# CITY OF ALBUQUERQUE

**Re: Staybridge Suites Meeting Room Addition, 5817 Signal Ave NE,  
Request for Permanent C.O. –Approved  
Engineer's Stamp dated: 05-31-11, (C18/D067)  
Certification dated: 05-01-12**

Based upon the information provided in the Certification received 05-03-12, the above referenced Certification is approved for a release of a Permanent Certificate of Occupancy by Hydrology.

NORTH POND RETAINING WALL PROFILE

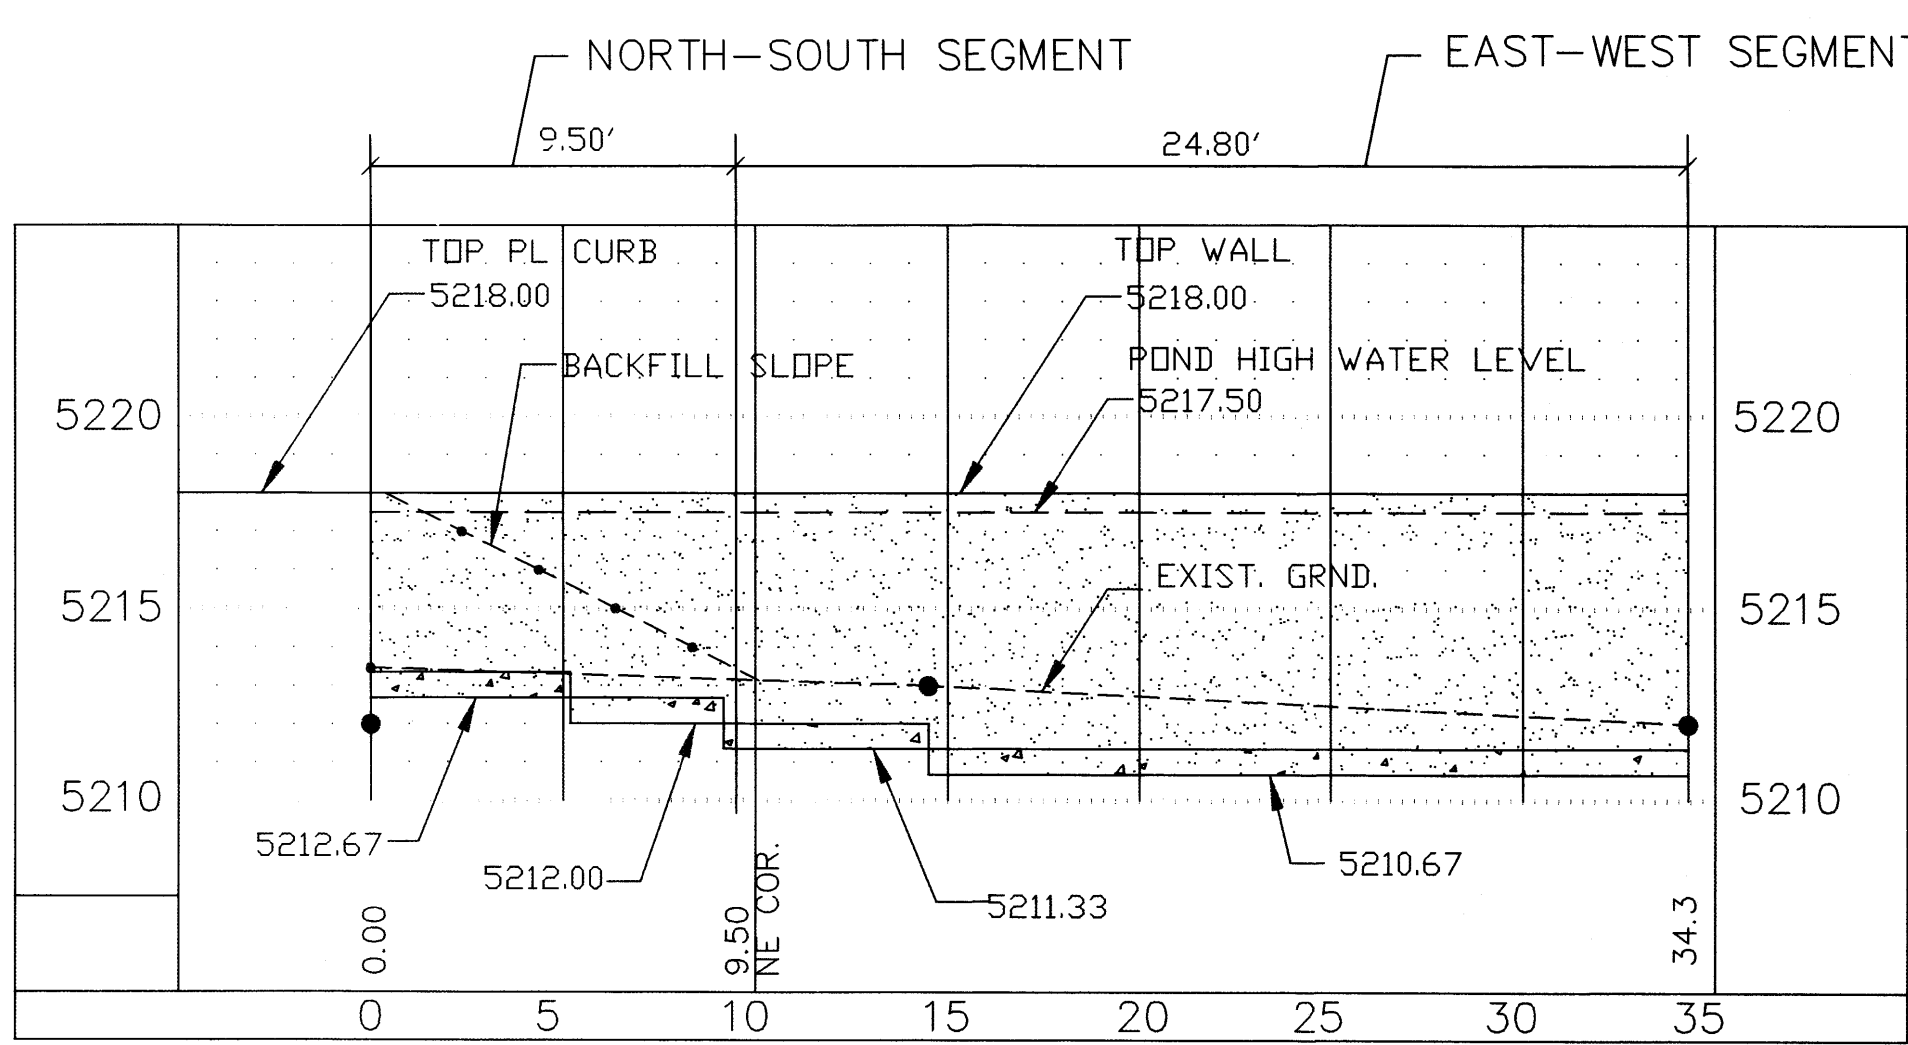
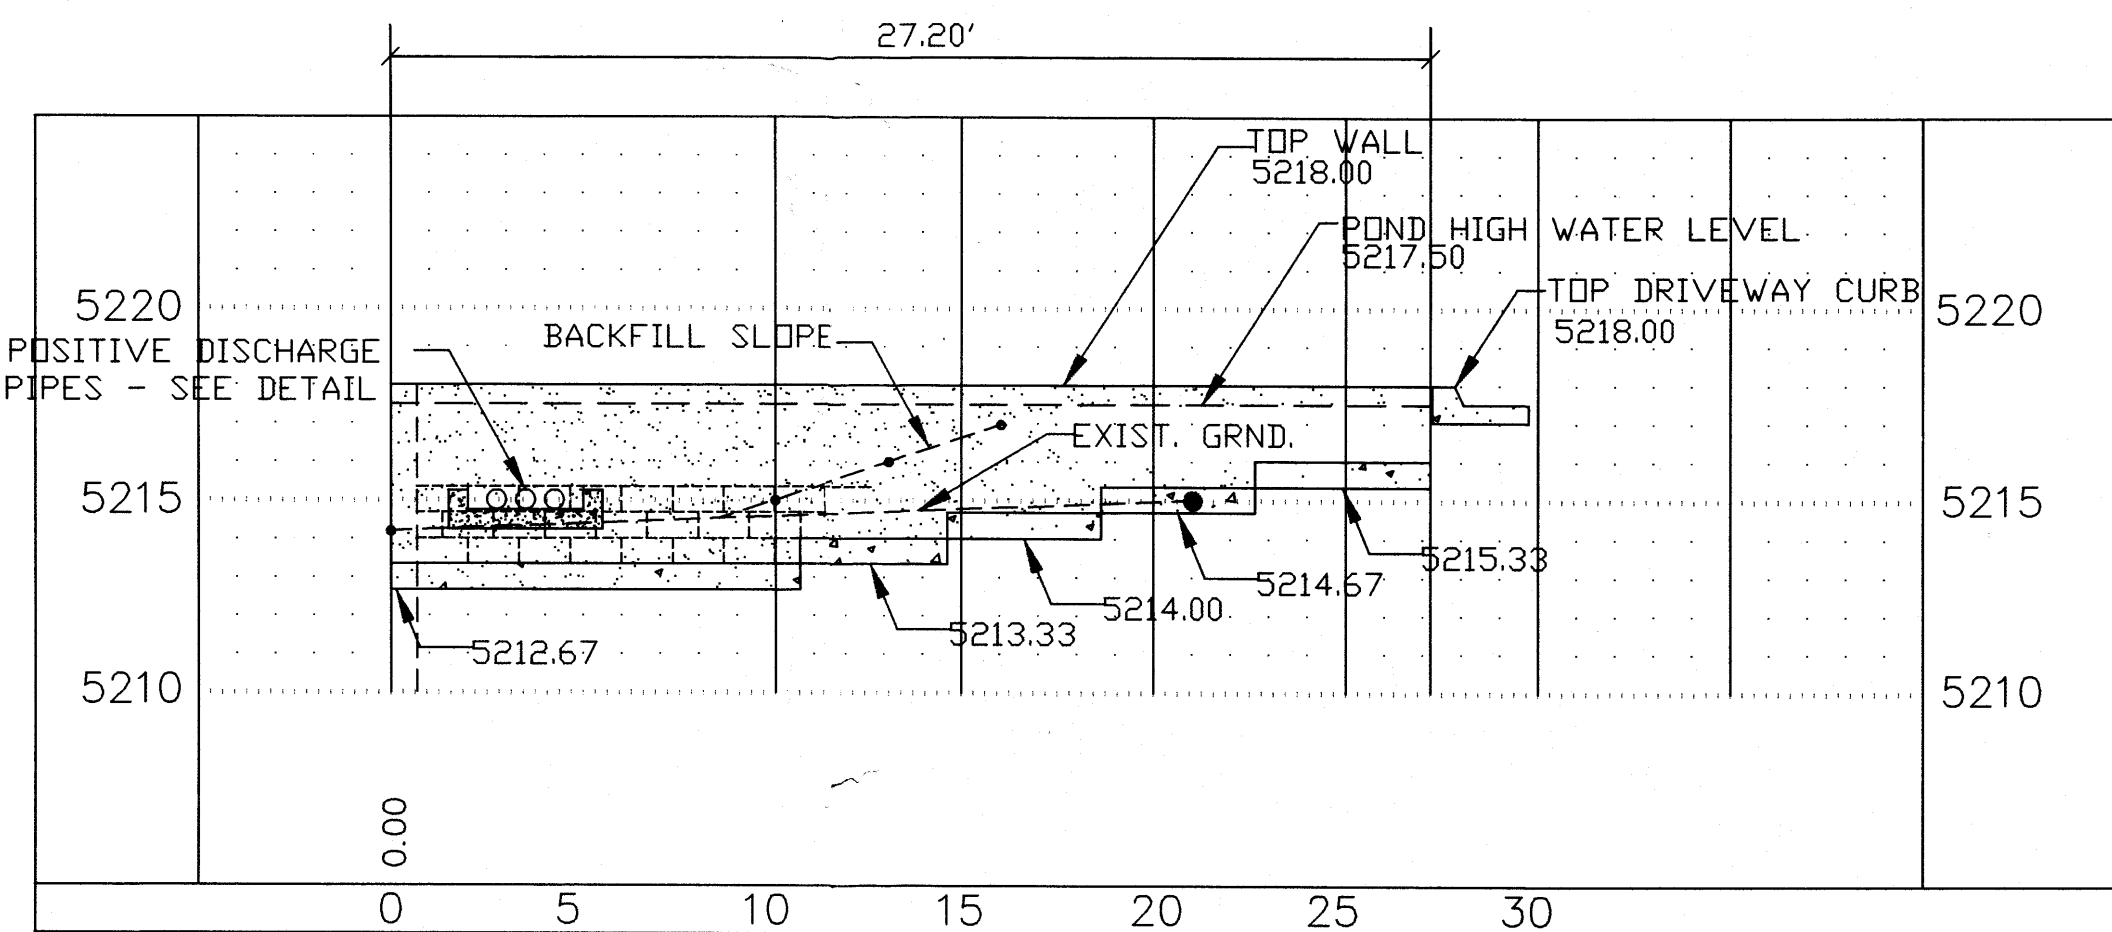
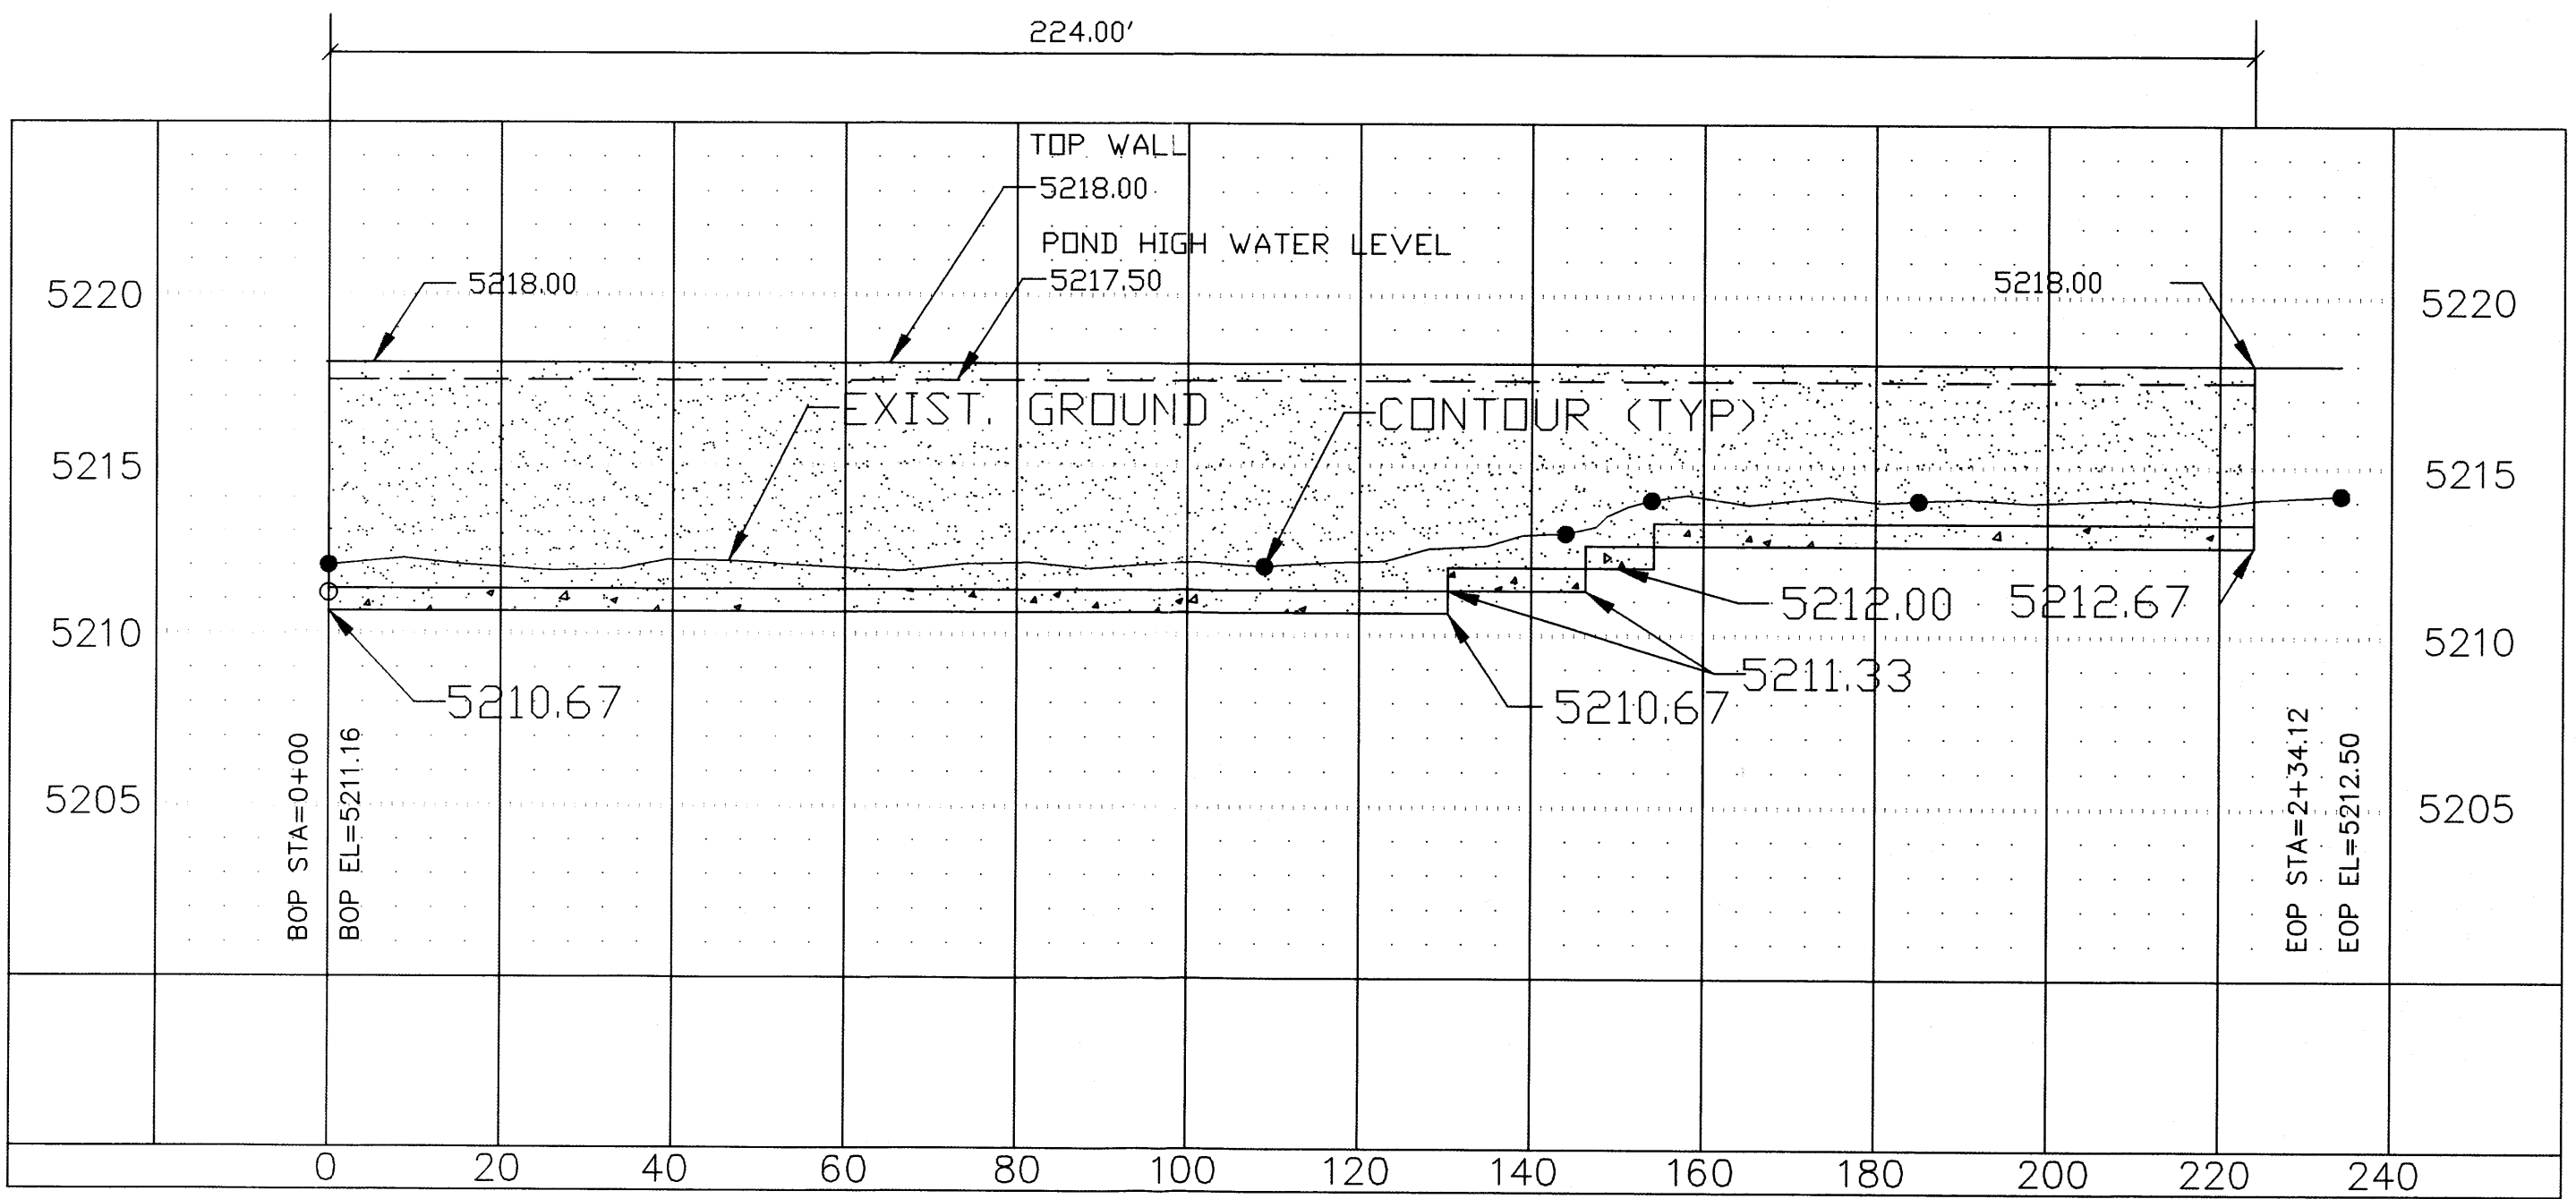
3. What are the extents of the pond retaining wall? Based on the wall profiles provided, the northern pond retaining wall only extends approximately 20 feet. However, based on the elevations shown, the northern pond retaining wall must be at least 190 feet long to prevent flow from entering

3. Again, the pond retaining wall has been called out by keyed notes. The north retaining wall extends from the NW corner of the parking lot to the north property line. I hope this is more clearly shown now. The final sentence seems to be unfinished so I hope I answered it adequately.

DETAIL A - 2' WIDE CONCRETE CHANNEL
SEE SHEET 1 OF 3, KEYED NOTE 18

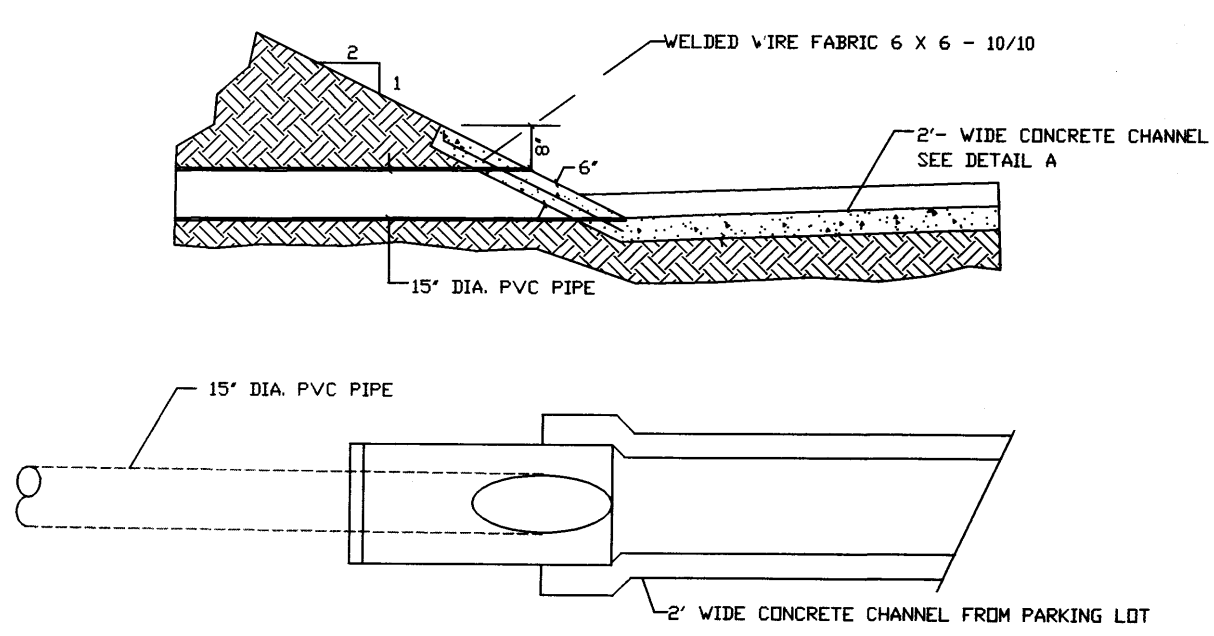
4. All work outside the property lines of this site must be completed through the work order process. Please add a note to this effect.
5. How is the flow guided from the 18" wide curb opening to the next drainage structure(s)? A channel appears to be shown on the plan. Is this the case? If so, please call out these channels and provide a detail.

6. Provide details for the splash pad, alley gutter, sidewalk culvert, and concrete channel (or refer to appropriate City Standards).

4. A note has been added regarding all work outside the property line being accomplished by the work order process.
5. For the east driveway, a two foot wide concrete channel has been added to convey the parking lot to the culvert and from the culvert to back into the parking lot and the culvert headwalls have been shown.
